From: Kate Giddings <kate.giddings@arun.gov.uk>
Sent: 21 July 2020 12:14
To: Anita Gardner <Anita.Gardner@arun.gov.uk>
Cc: Planning.Responses <Planning.Responses@arun.gov.uk>
Subject: CM/20/20/PL

1091/DPA01

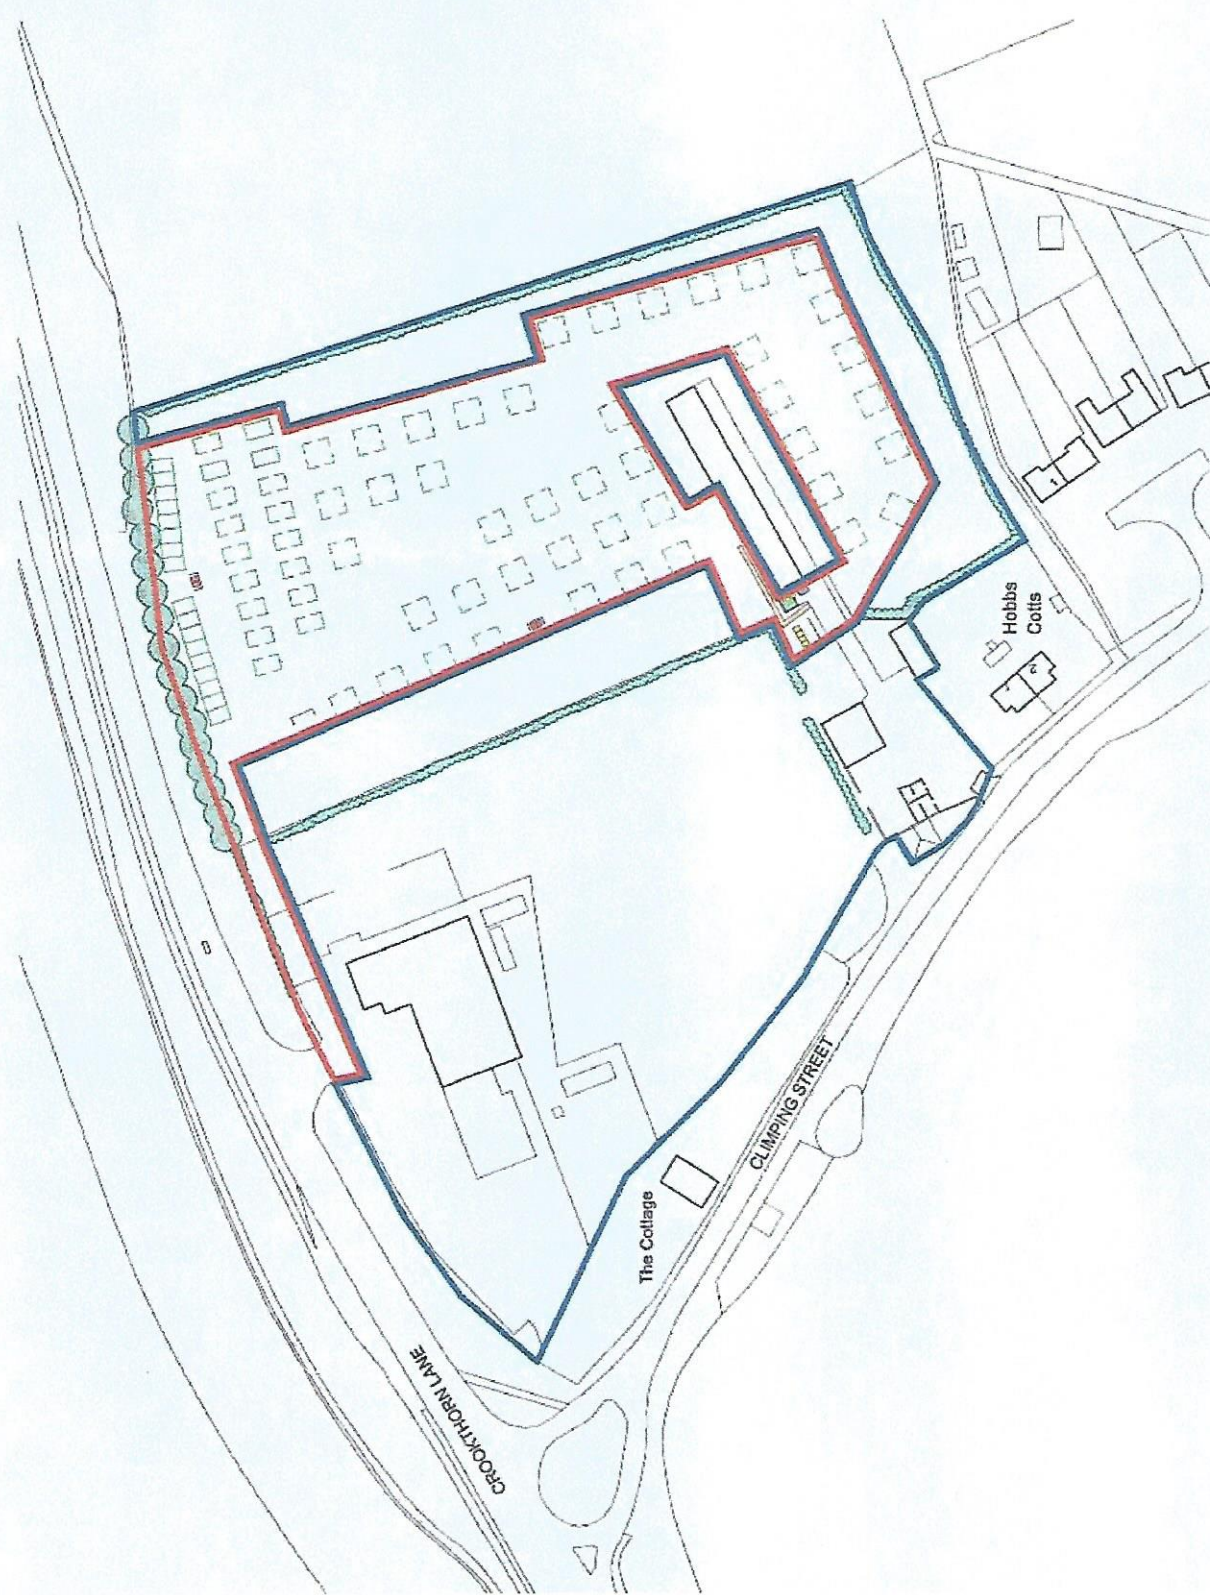
Every tent shall be placed at a minimum distance of three metres apart from any other tent, with a minimum distance of one metre between the guy ropes of one tent from the guy ropes of another. Every caravan shall be stationed a minimum of six metres from another caravan. No caravan or combustible structure shall be positioned within three metres of the site boundary. Providing that the number of proposed pitches is capable of adhering to this spacing requirement, EH has no comments regarding this application.
